Our Ref: BE/74/19/PL

**Town & Country Planning Act 1990 (as amended)
Town and Country Planning (Development Management Procedure) (England) Order 2015
Application for Planning Permission**

Development Construction of entrance door & ramp on east elevation
Location 218 Chichester Road North Bersted

1:200
LOCATION &
BLOCK PLAN.
218-222 Oct
2019.

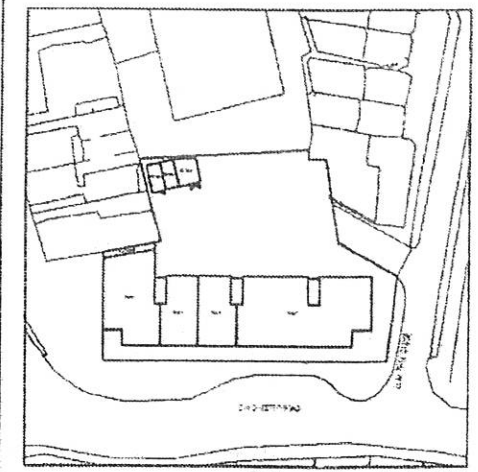
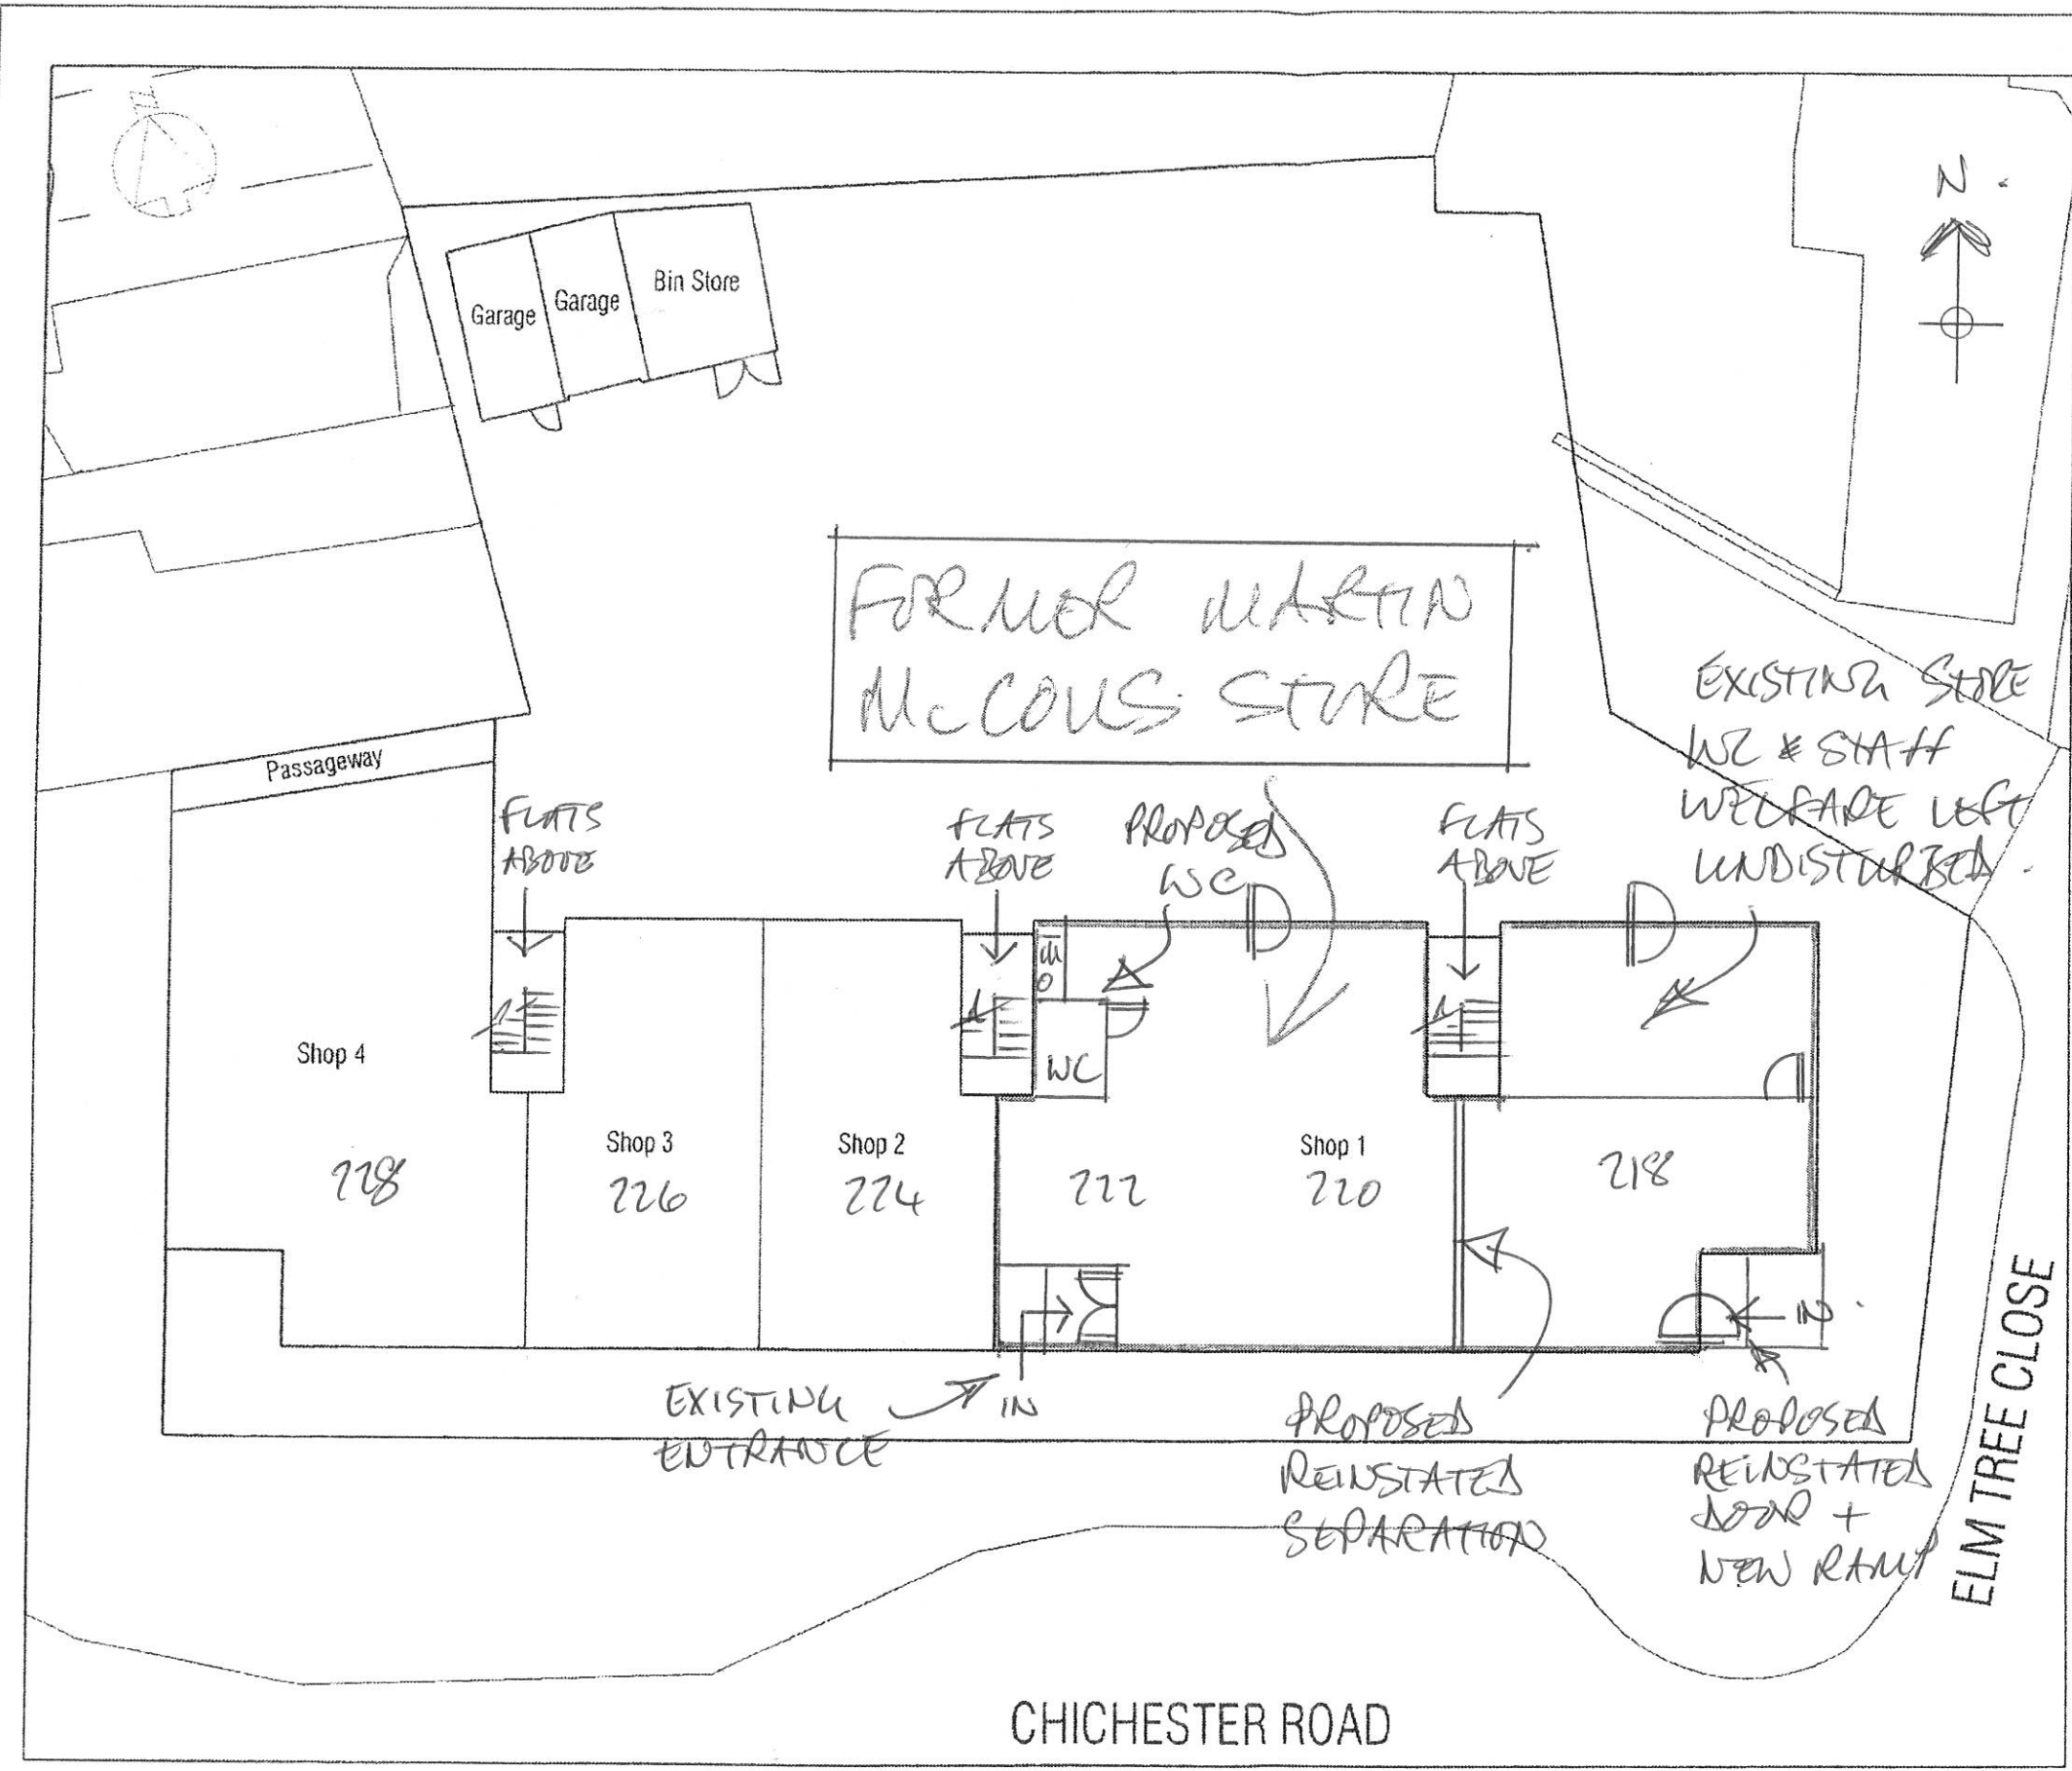
Block Plan

Please submit 1 electronic or 3 paper copies of an amended block/site plan at a scale of 1:500 or 1:200 showing the proposal.
